Your ref:
Our ref: 22/01559/F
Please ask for: Amy Davies
Direct dial: 01553 616879
E-mail: borough.planning@west-norfolk.gov.uk

Details: **Detached 3-bed dwelling bungalow and on-site parking. at 47 Main Road
Brookville THETFORD Norfolk IP26 4RB**

I have received a planning application as detailed above but cannot process it until I receive some more information:

Drawing
Proposed Floor Plan, Elevations & 3D

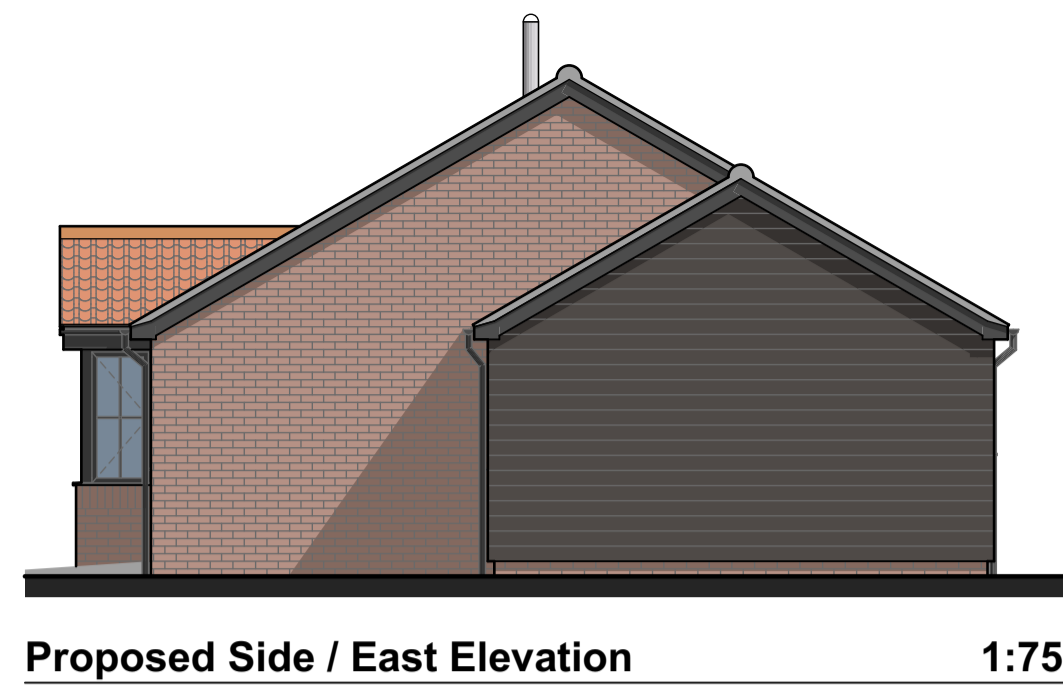
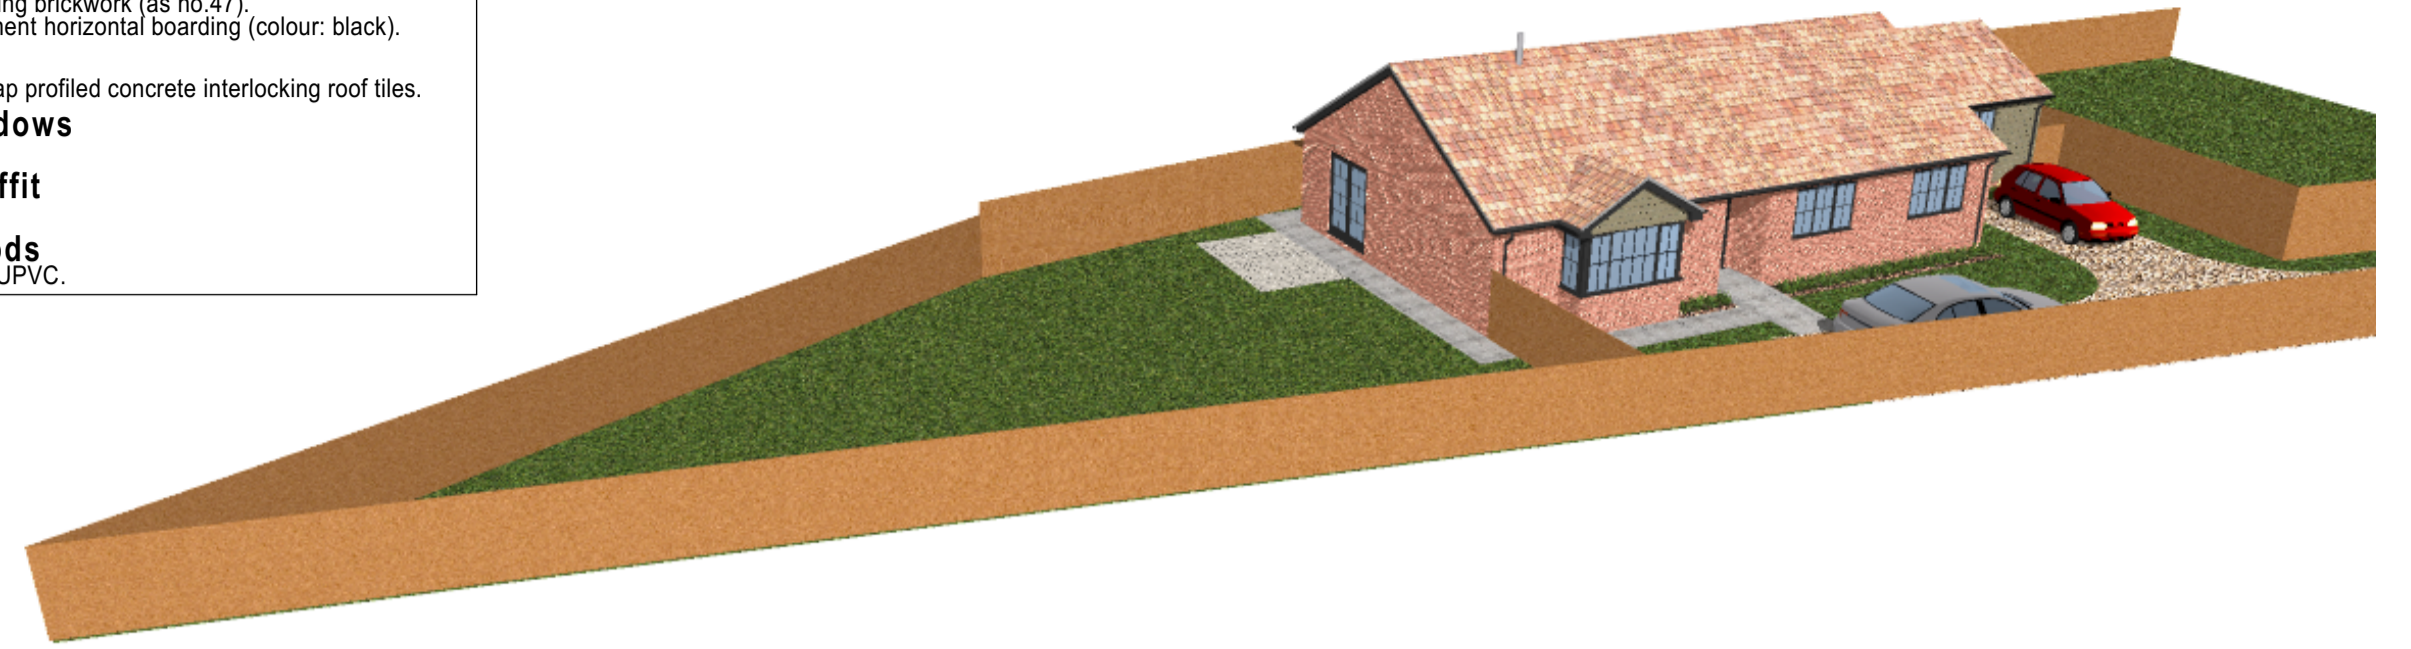
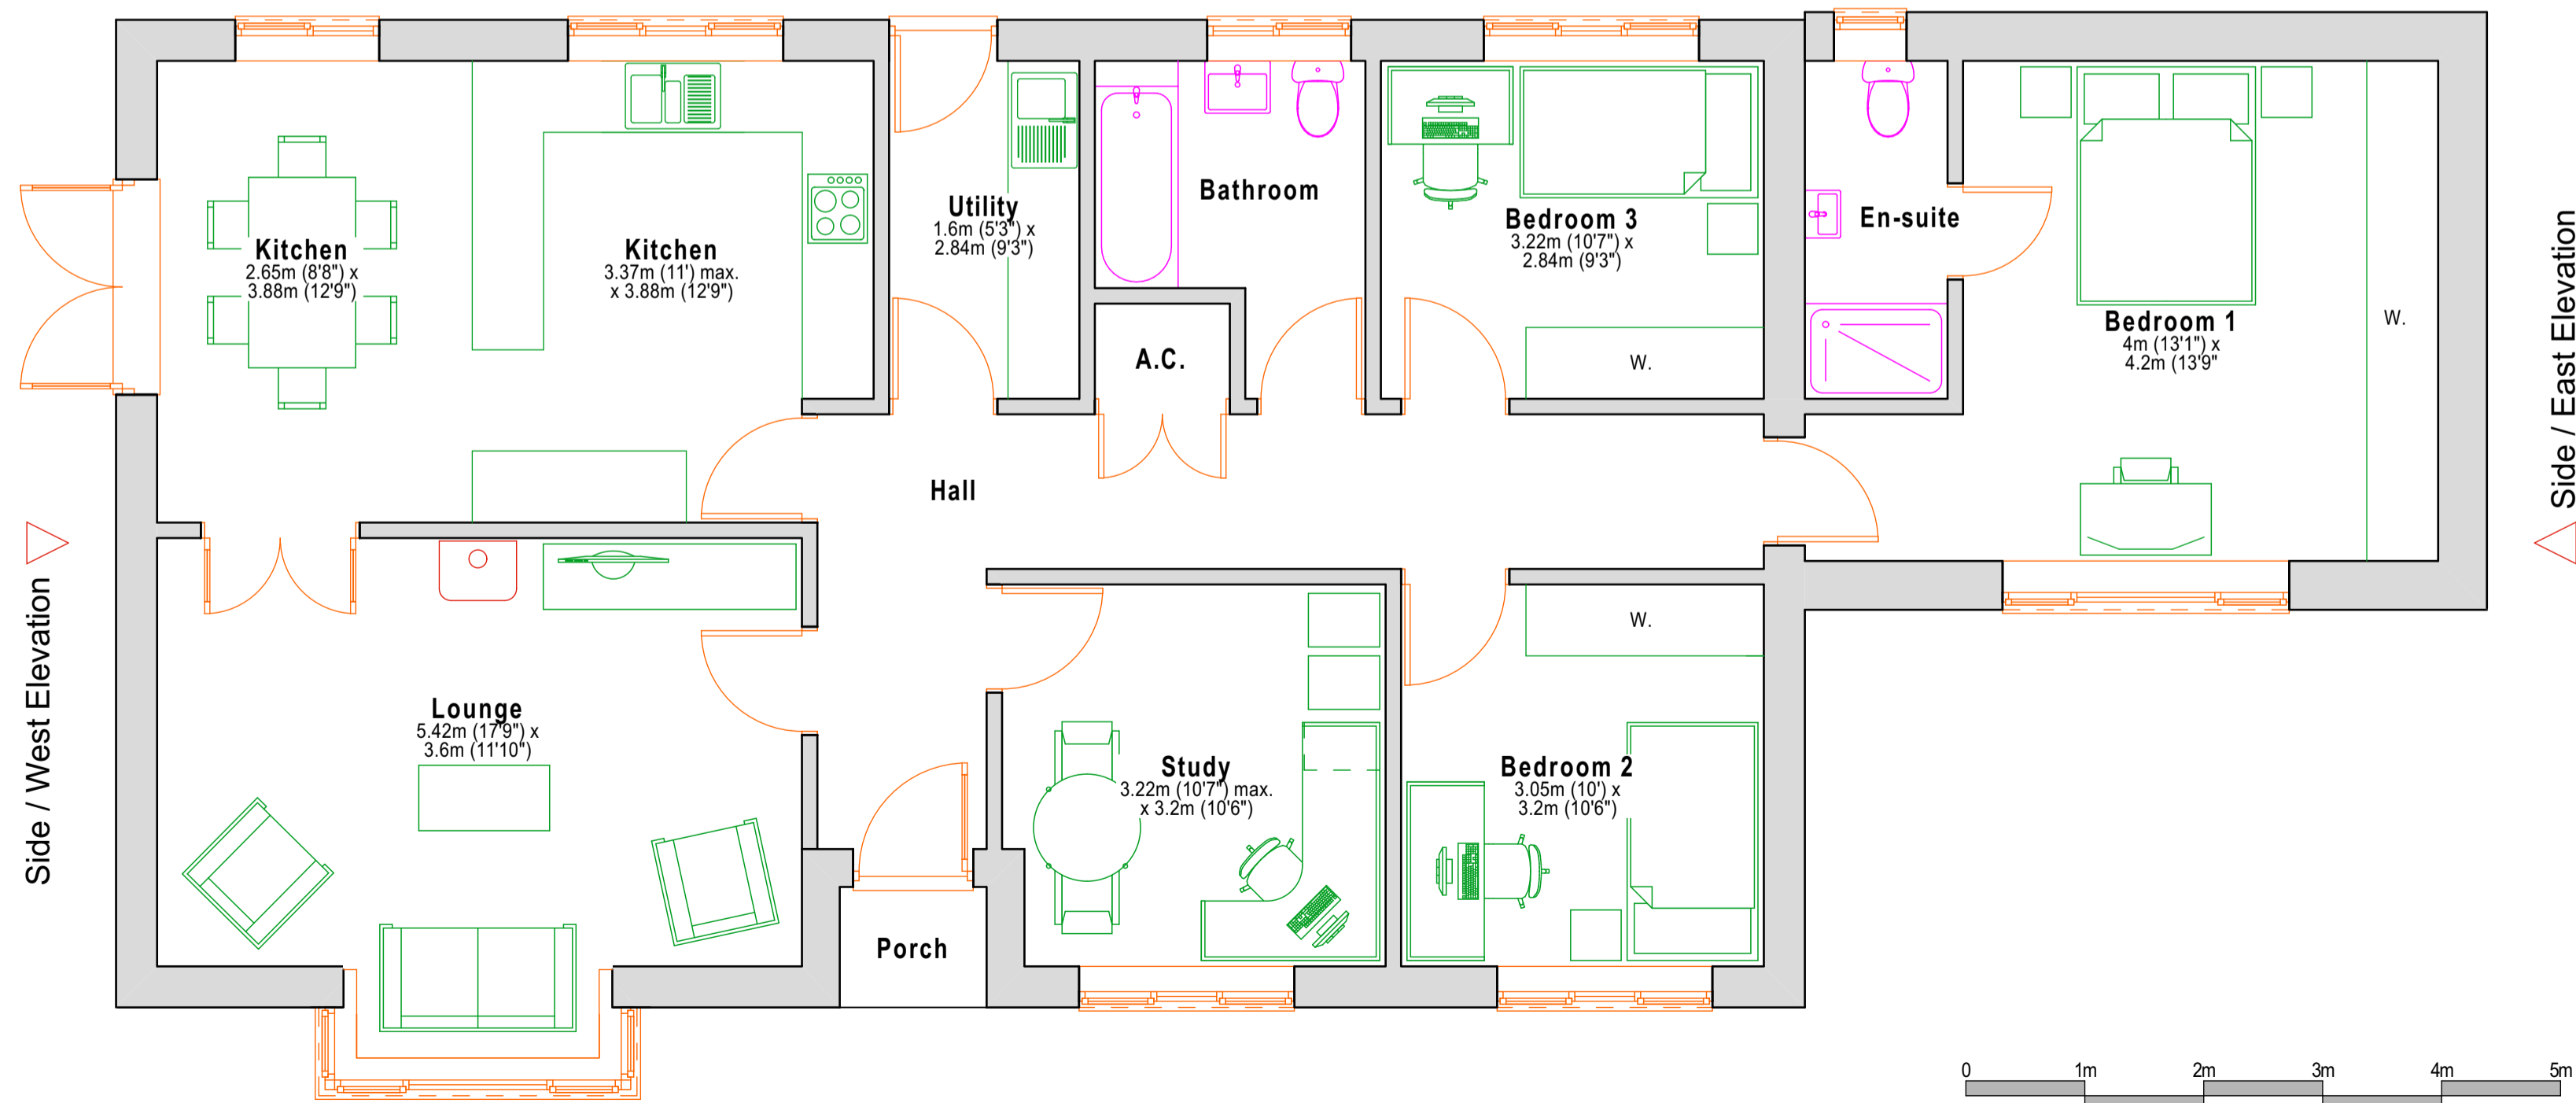
1. Please provide drawings to a recognisable scale, showing existing and proposed site levels. If the site levels are to remain unchanged, please provide the drawings annotated as existing and proposed.
2. Please provide a block plan to the correct scale of 1:100, 1:200 or 1:500.
3. We received £50 for the Habitat and Mitigation fee from your previous application, but unfortunately this has gone up to £185.93 so there will be a remaining balance of £135.93 left to pay.
4. Please provide a section thought plan of the proposed dwelling, this should be done to a scale of 1:50 or 1:100 .
